Your ref:
Our ref: 24/00056/F
Please ask for: Valera Lvov
Direct dial: 01553 616865
E-mail: borough.planning@west-norfolk.gov.uk

TOWN AND COUNTRY PLANNING ACT 1990

Details: **Insertion of 3 Velux Conservation Roof Windows to north roof slope of single storey rear projection; combination of two external openings to south wall of single storey rear projection and formation of single larger opening with powder coated aluminum sliding doors; replacement of existing access door to rear gable wall of single storey rear wing with glazed timber window; mounting of solar PV panels on south roof slope to single storey rear wing. at The Porch House Hall Lane Thornham Hunstanton Norfolk**

File No: 2023/18 Drawing No: 3/B

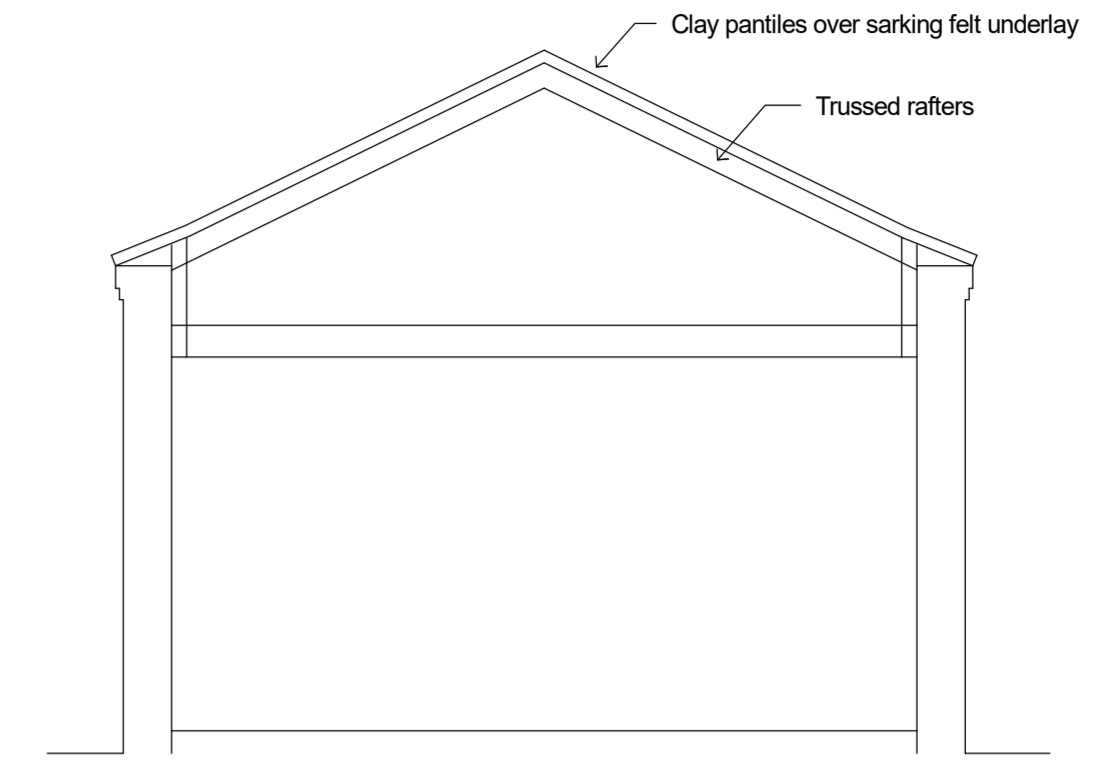
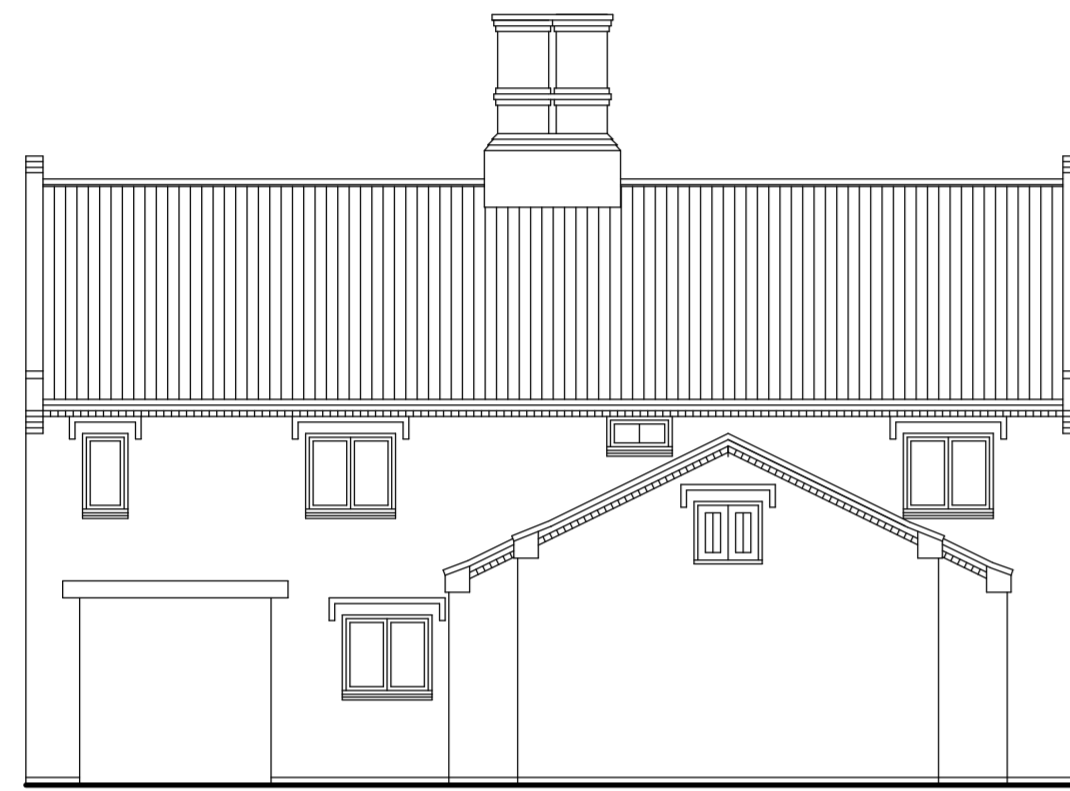
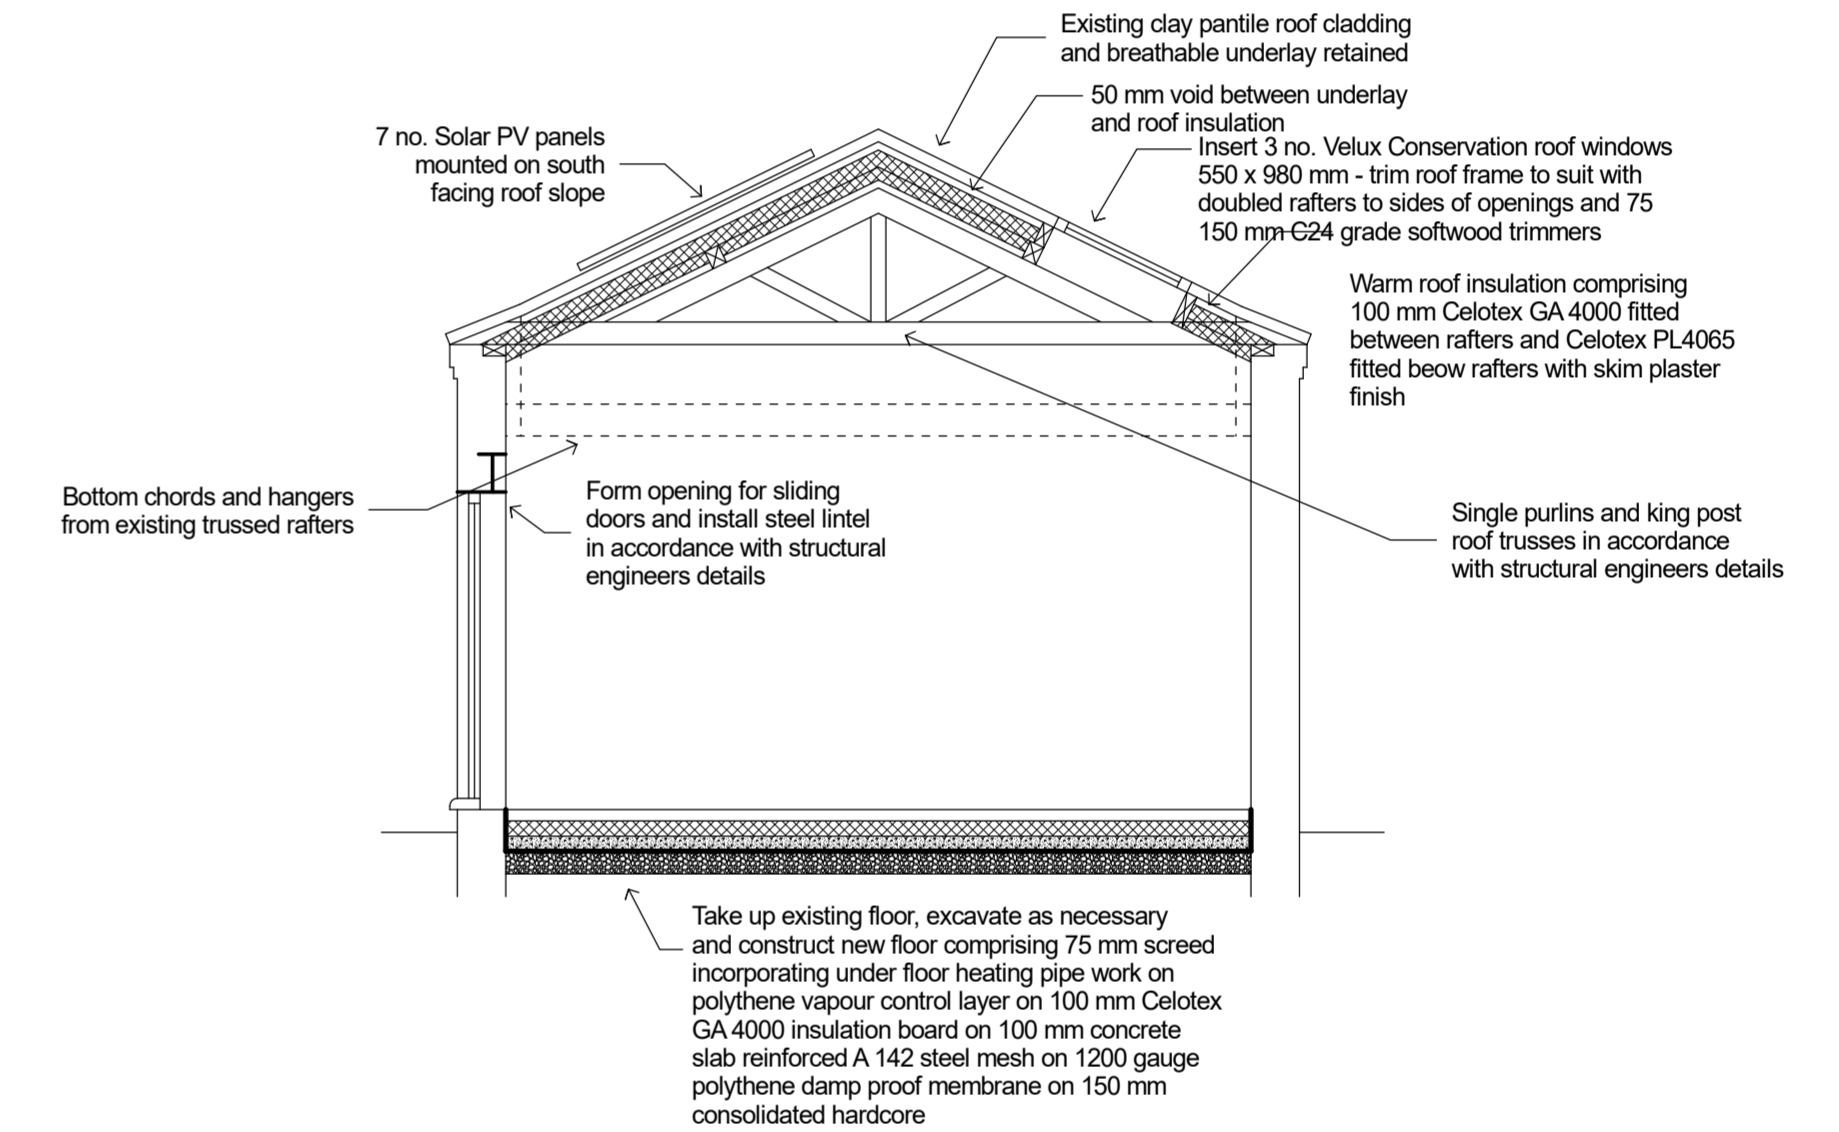
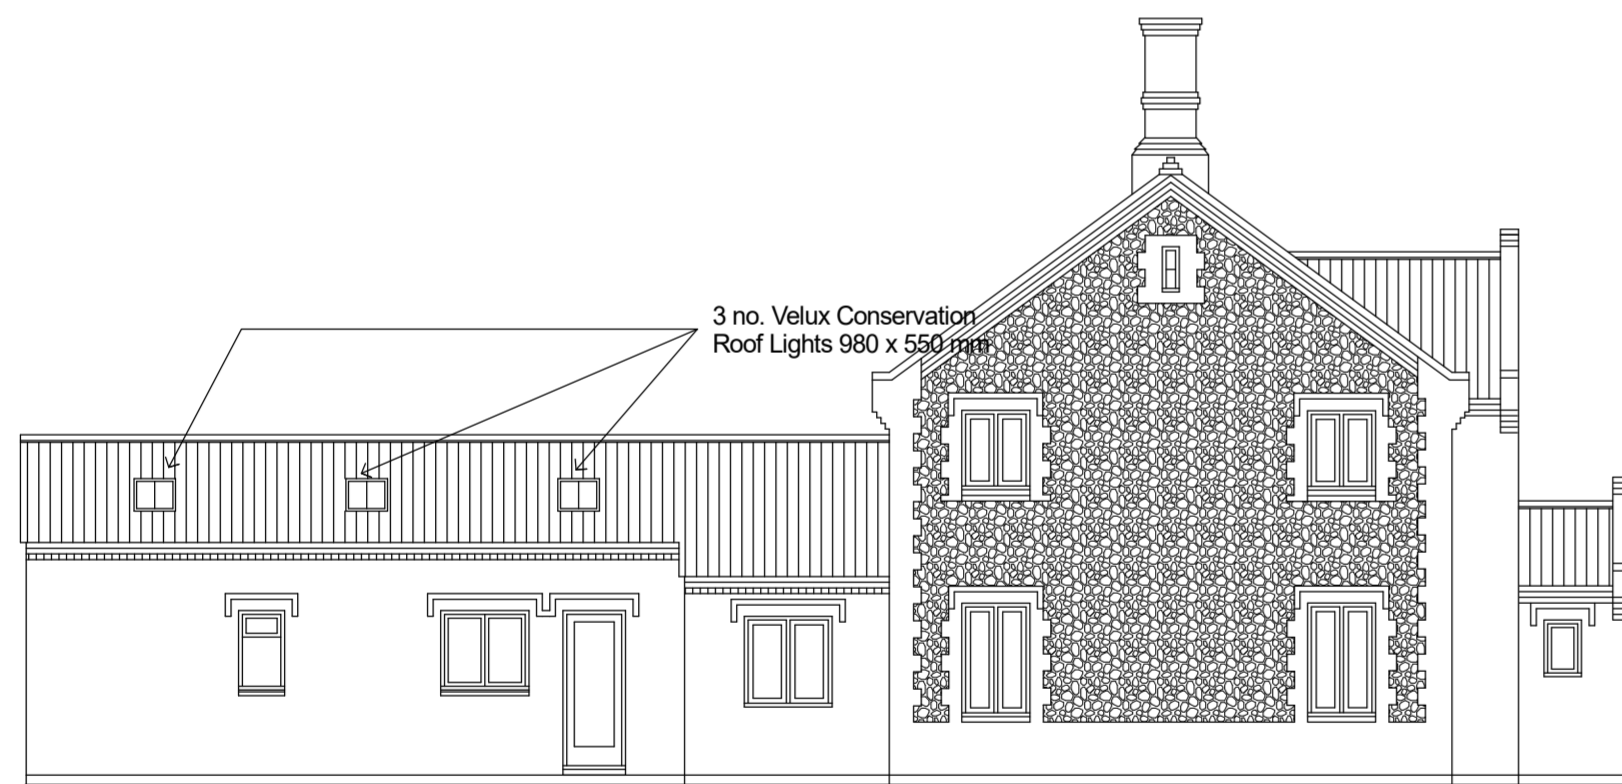
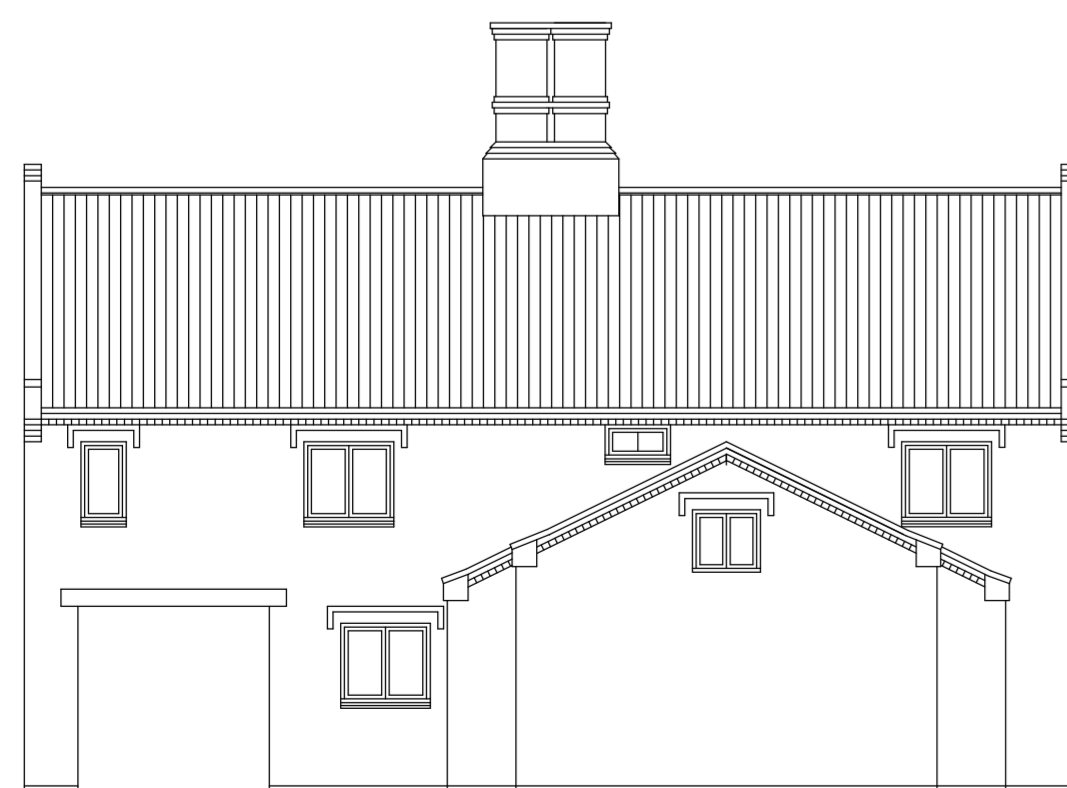
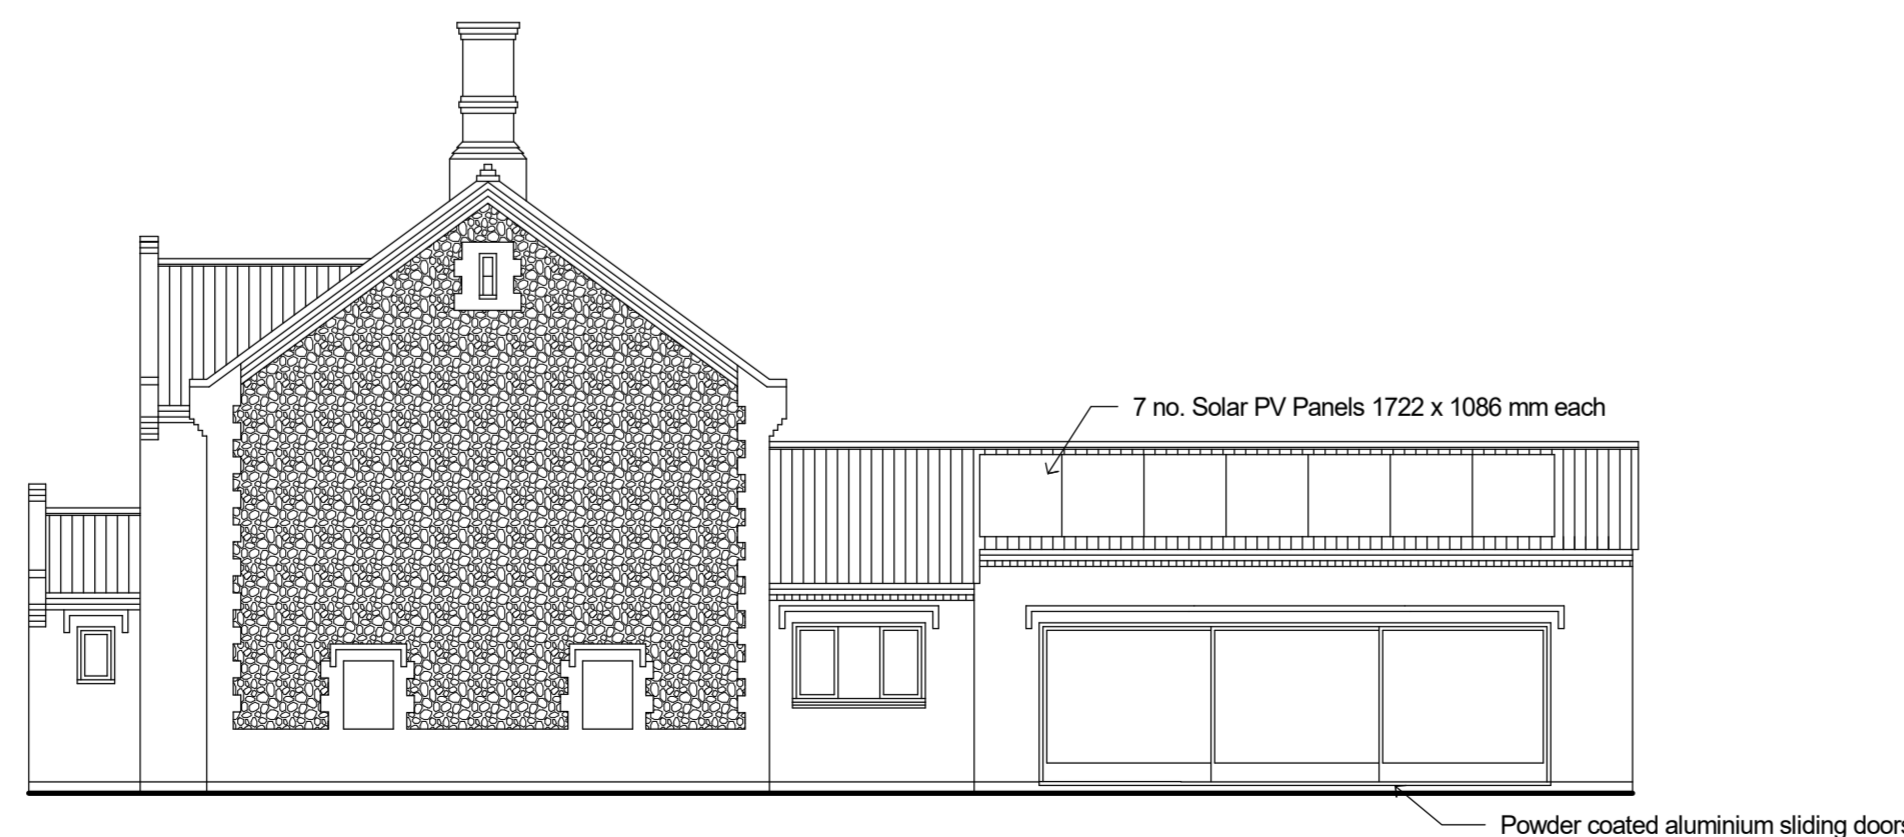
1. Please amend the drawings. Drawings annotated "Not to Scale" or "Do Not Scale" or similar wording will result in the application being invalidated. All drawings must be drawn true to the stated scale(s).
2. Please provide a Roof plans to a scale of either 1:50 or 1:100
3. Can you confirm if you are happy to shorten the proposal description to the following;
"Alterations and repairs to the existing building and installation of Solar PV panels."
